REQUEST

Current Zoning: N1-A (neighborhood 1-A)
Proposed Zoning: UR-2(CD), 5-year vested rights (urban residential, conditional)

Approximately 53.07 acres located on the east side of Elm Lane and west side of Rea Road, south of Bevington Place.

The petition proposes to develop a residential community containing multi-family, single family attached and detached dwellings on the site currently developed with one single family dwelling in south Charlotte.

**REZONING SITE PLAN**  
 PETITION NO. RZP-2022-121

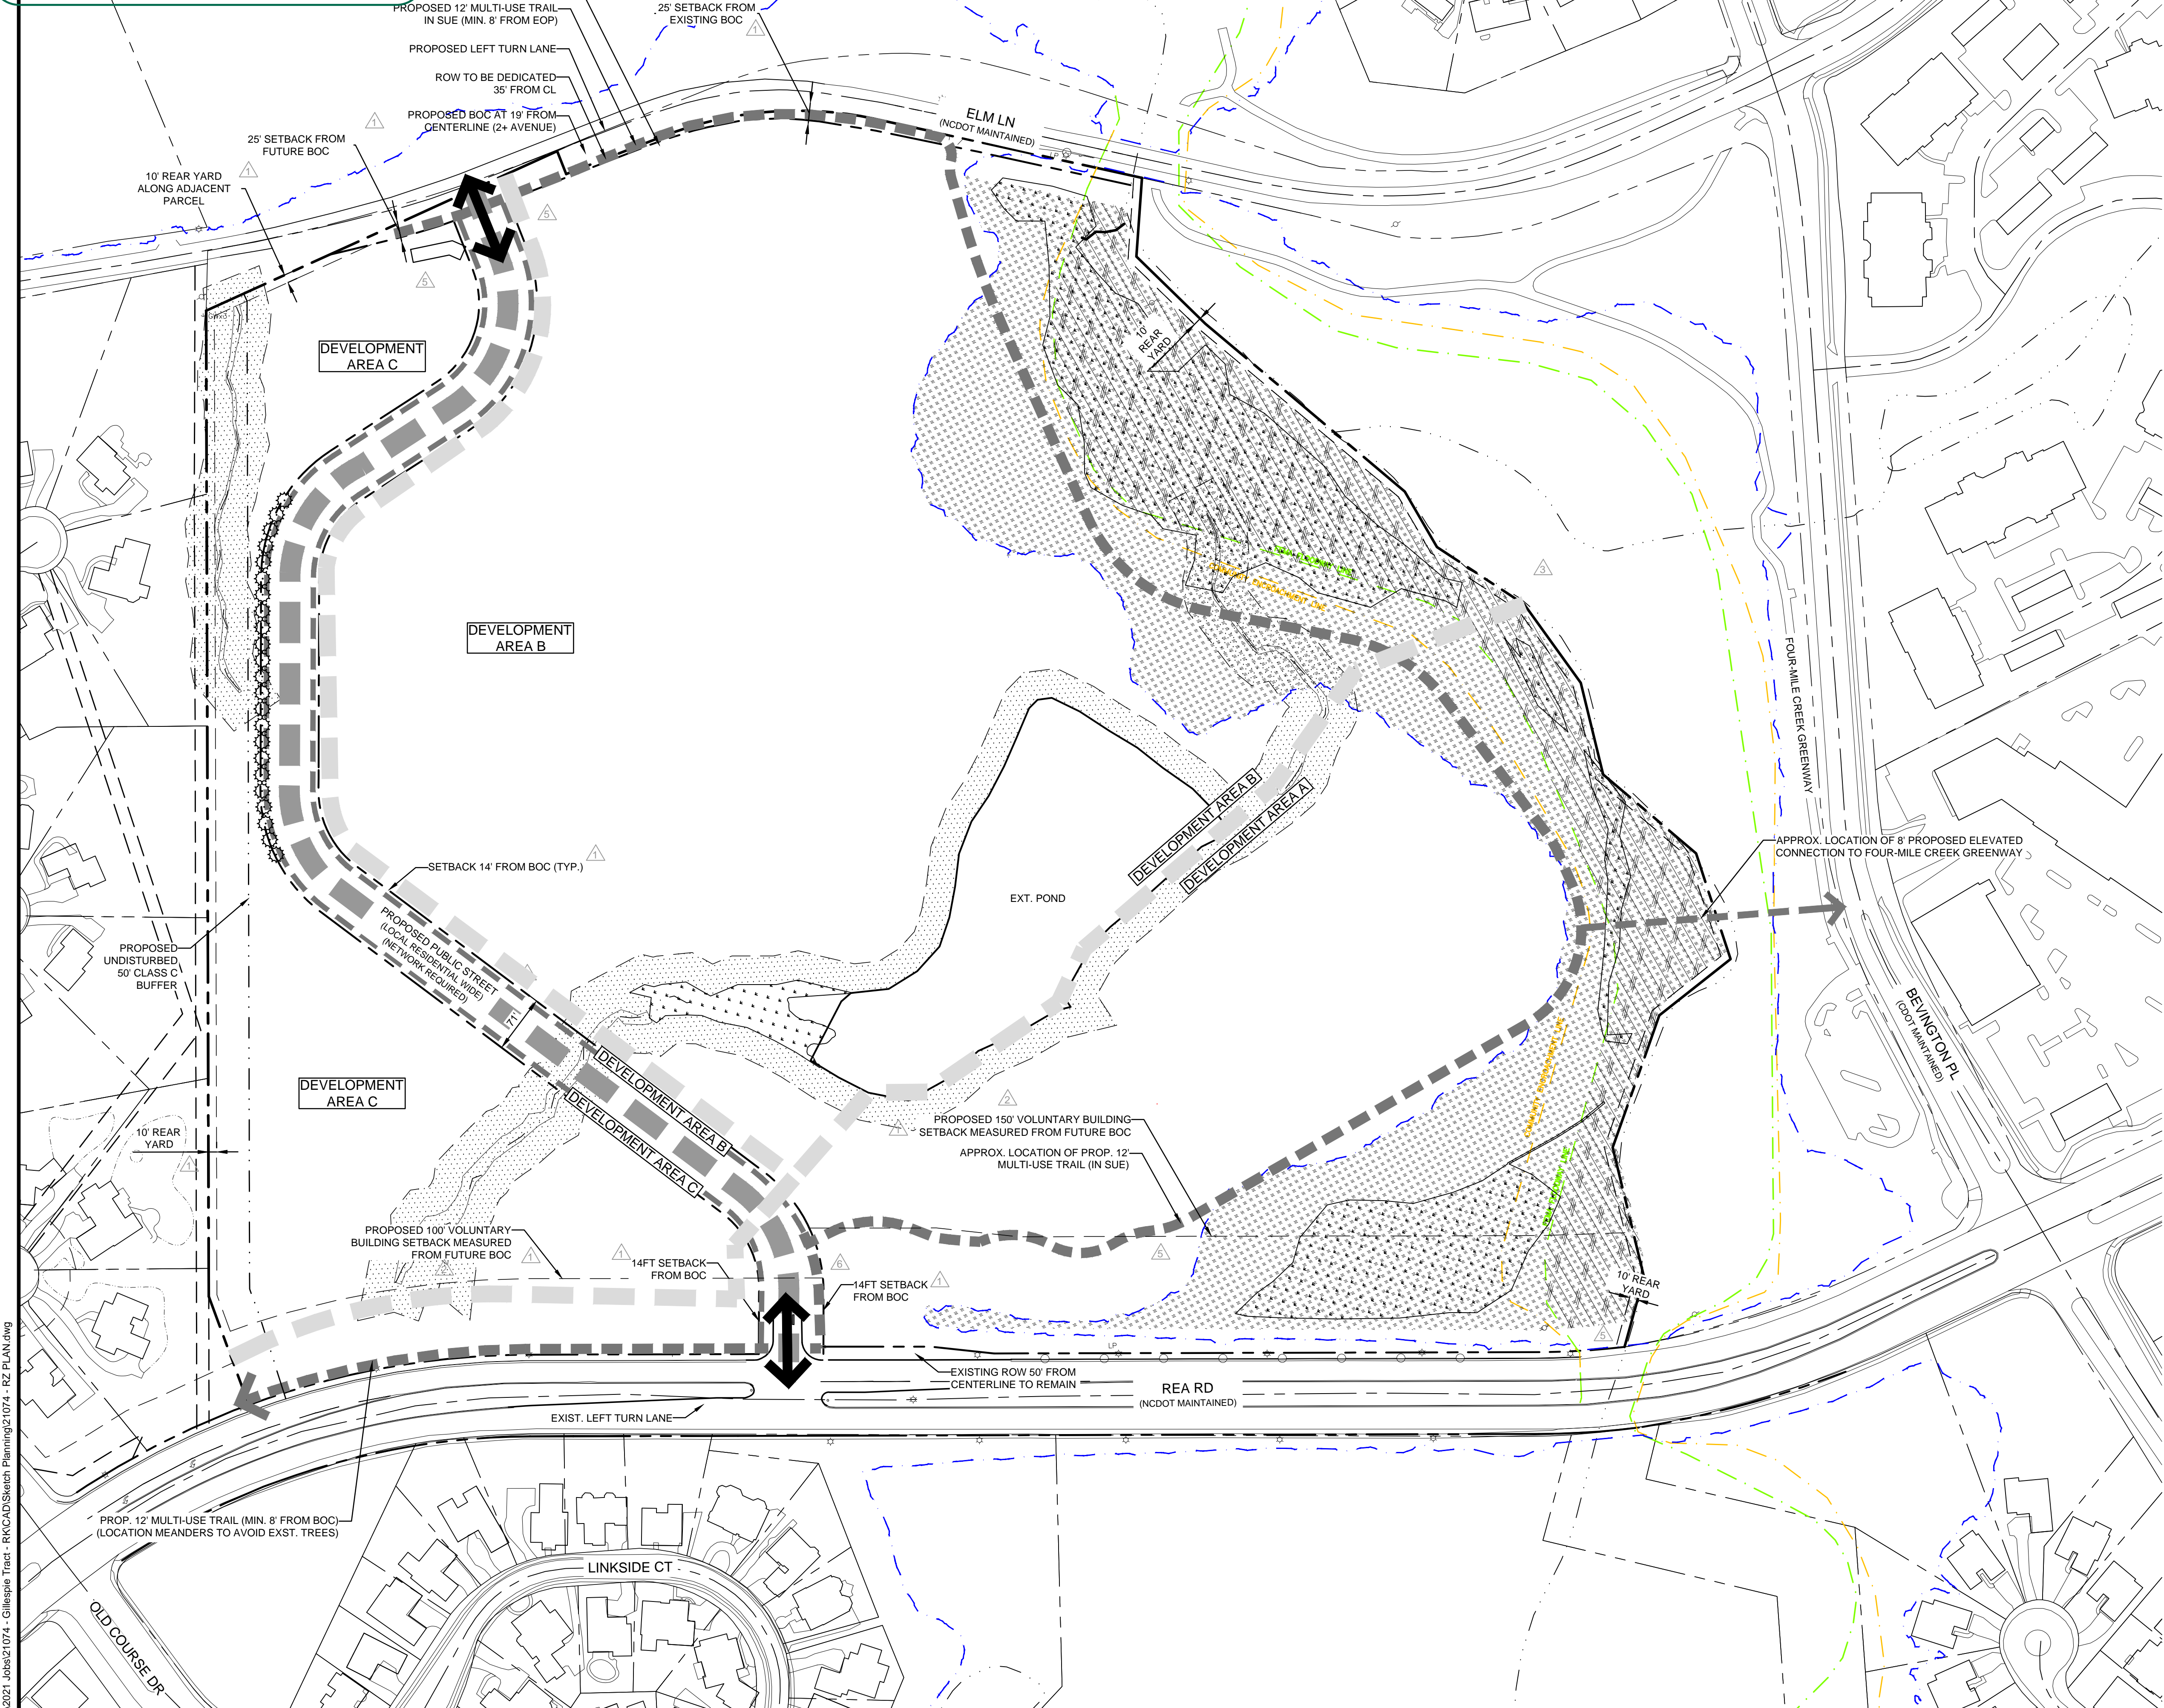
3. Reorient the building between the Pvt Alley and Rea Rd. south of the proposed street so that fronts Rea Rd. **Addressed the petitioner is providing landscape screening along the Pvt Alley.**

4. Relocate proposed parking area at the southeast corner of the intersection of Elm Ln and the proposed public street so that it is internal to the development. **Addressed.**

5. Relocate proposed parking area at the northwest corner of the intersection of the proposed public street and Pvt Alley so that it is internal to the development. **Addressed**

6. Clarify how pedestrian connection will be made from Rea Rd. to the proposed internal 12' multi-use path. **Addressed.**
7. Remove/modify notes 3.2.3 and 3.2.4 to clarify that additional multi-family units would not replace single family attached units shown on the plans. **Addressed**
